Re: Roberts Road Quarry MOD 2 (DA 267-11-99)

**Proposed Modification Request to an Existing Extractive Industry
Hodgson Quarry Products – Lots 1 and 2 DP 228308 and Lot 2 DP 312327, Roberts
Road, Maroota**

**Roberts Road Quarry Modification 2 (DA 267-11-99 Mod 2)
Response to exhibition of Environmental Impact Statement**

Roberts Road Quarry Modification 2 (DA 267-11-99 Mod 2) Response to exhibition of EIS Detailed comments - DPI Water

SCALE 1:100

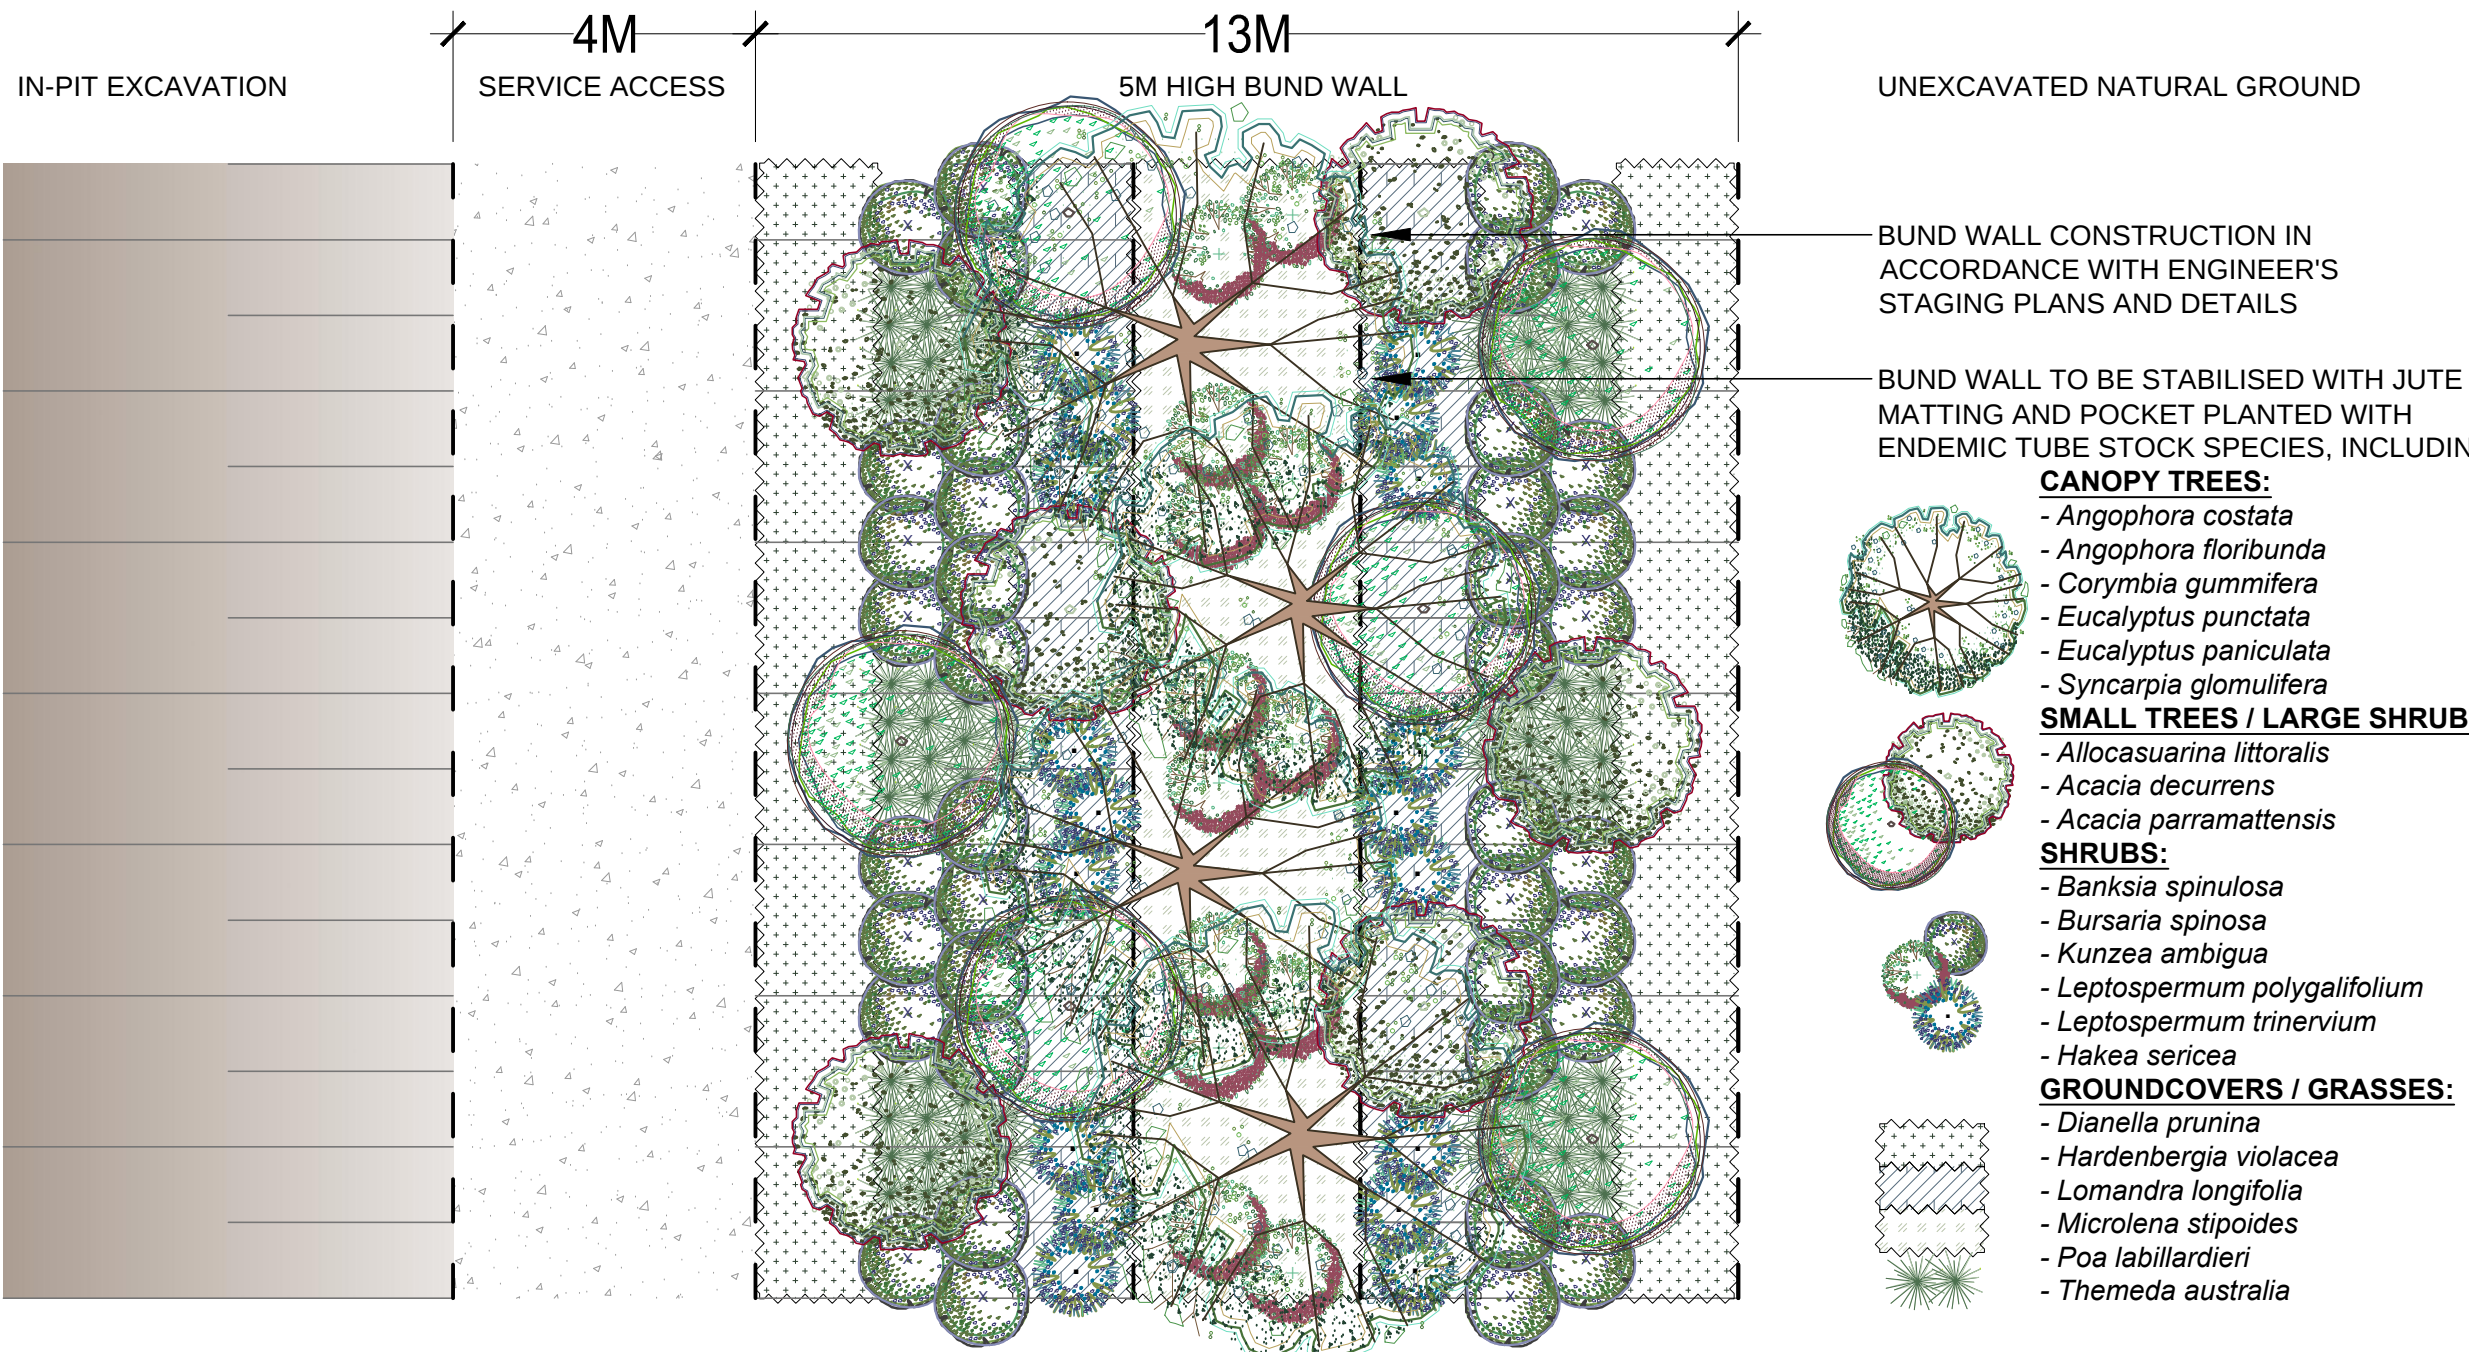
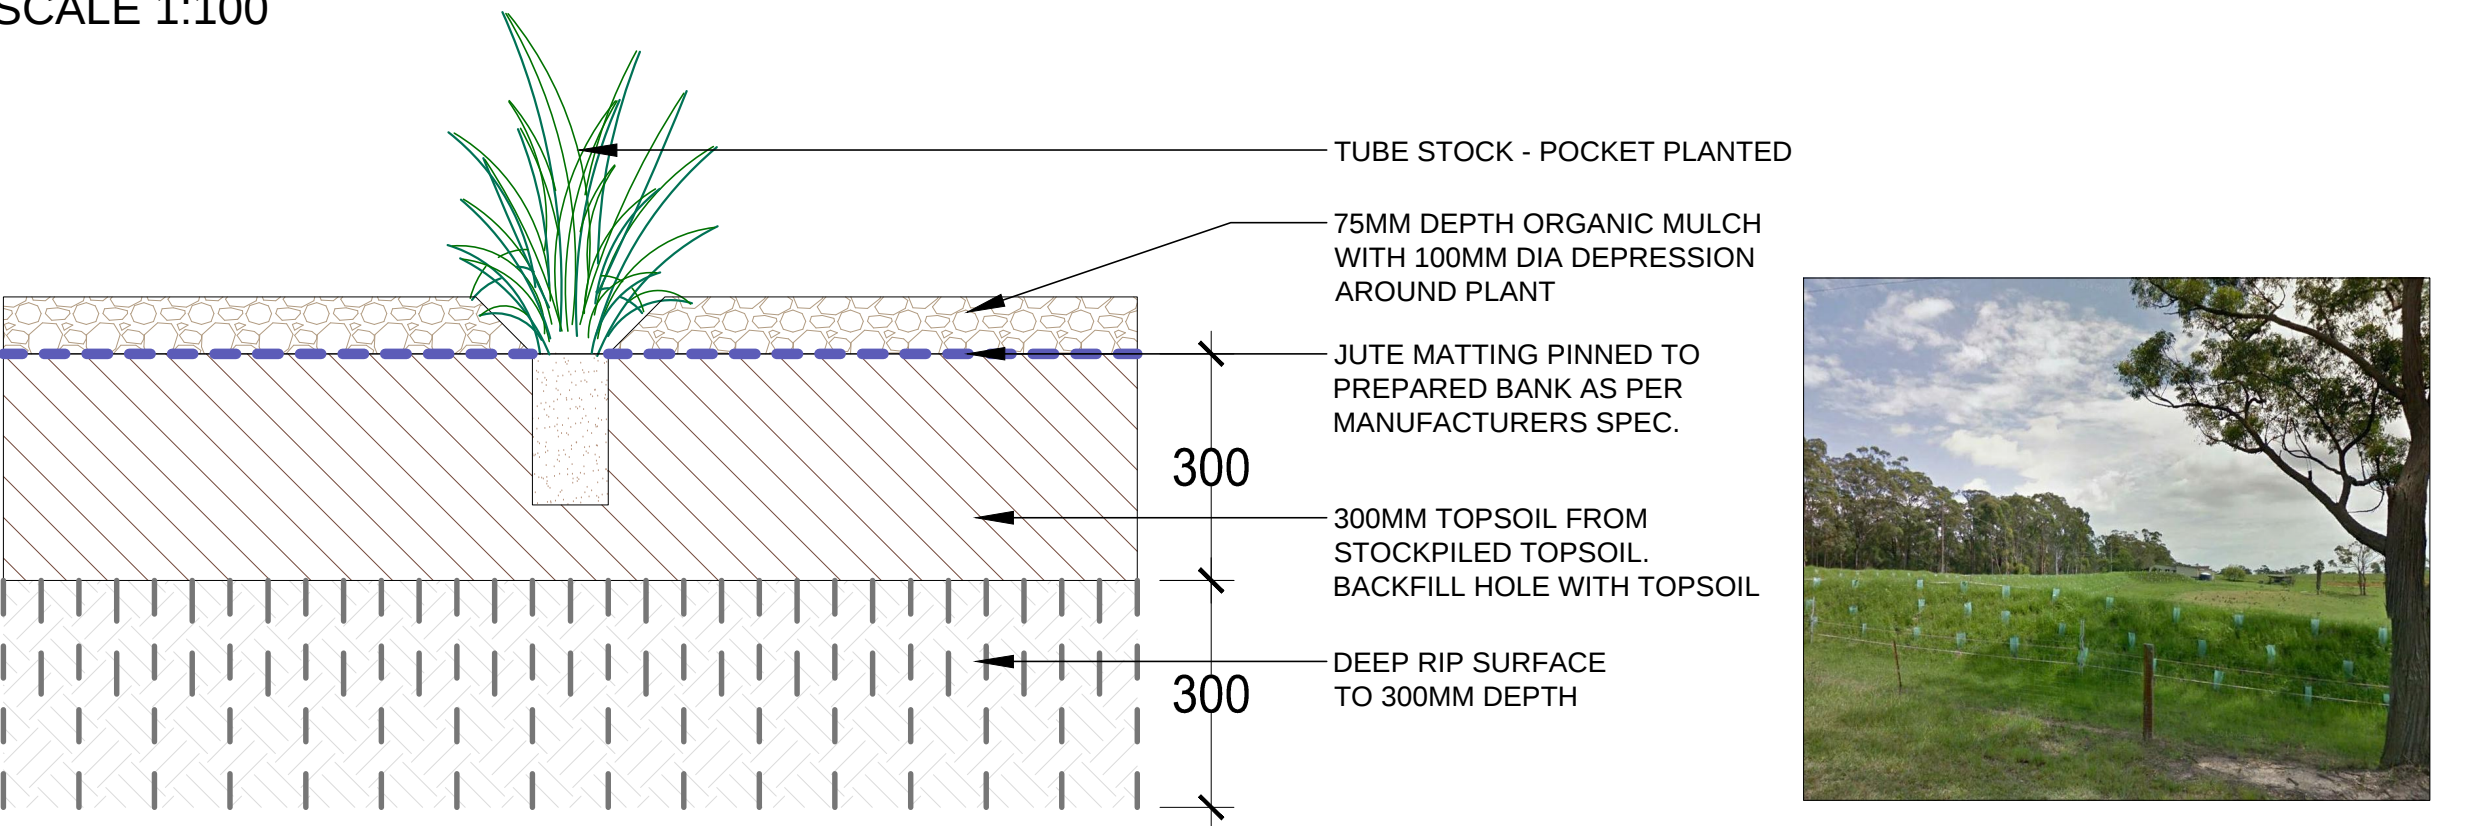
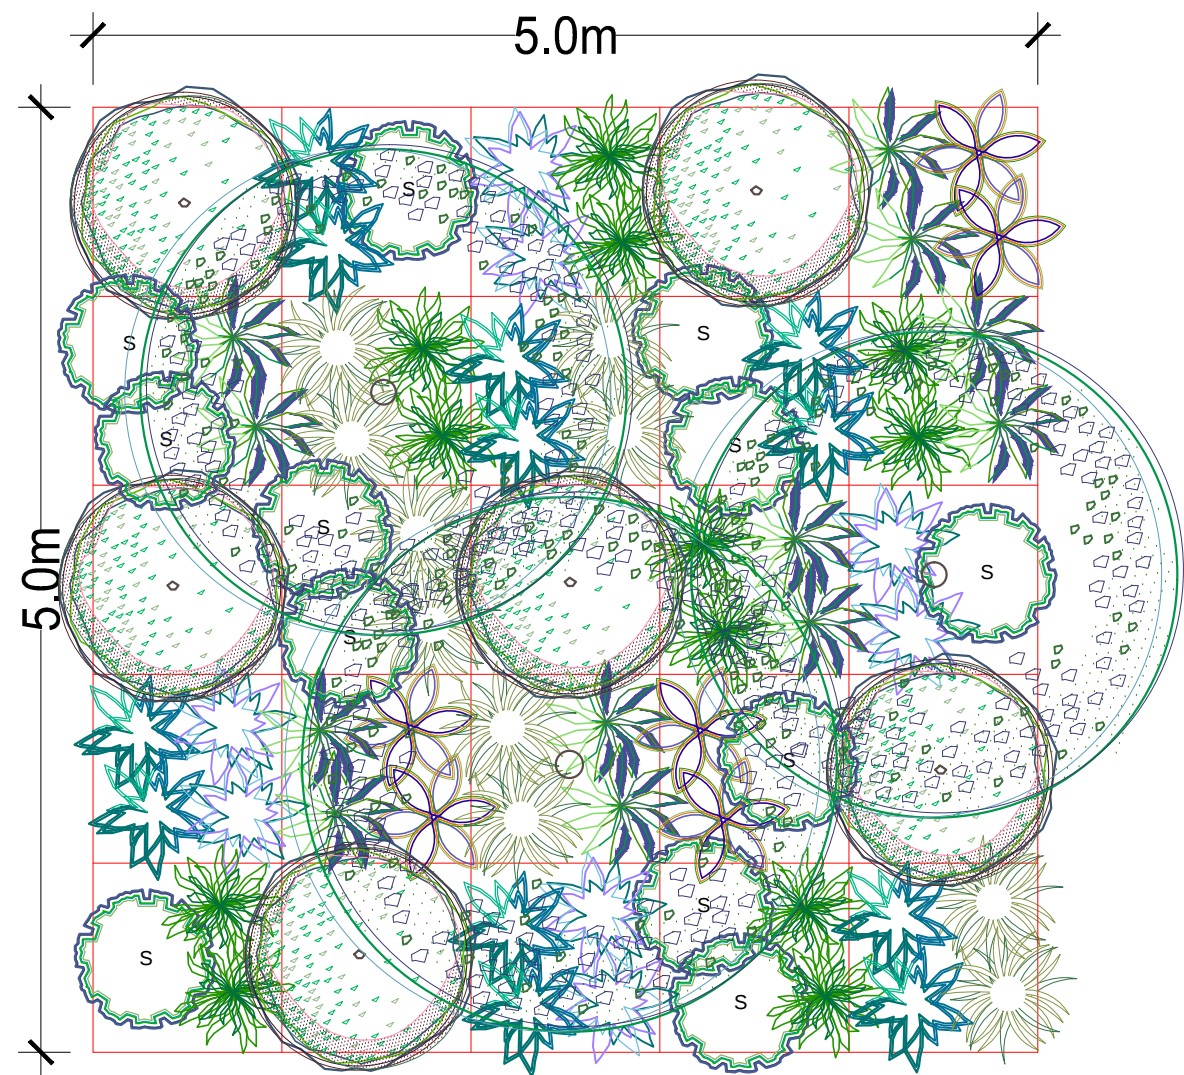
1. The modification application does not adequately consider potential impacts to adjoining property owner's given the additional period requested for extraction. Of particular concern is the visual impact of the proposal. The Statement on page 3-69 refers to the original EIS and refers to '*extensive screen planting, supplemented with earth bunding...*'

In this regard some bund walls have been constructed with some landscape works. The bund walls provide a reasonable screen however the landscape works undertaken are not consistent around the boundary and does not provide an adequate screen.

Additional landscape work is required to reduce visual impact.
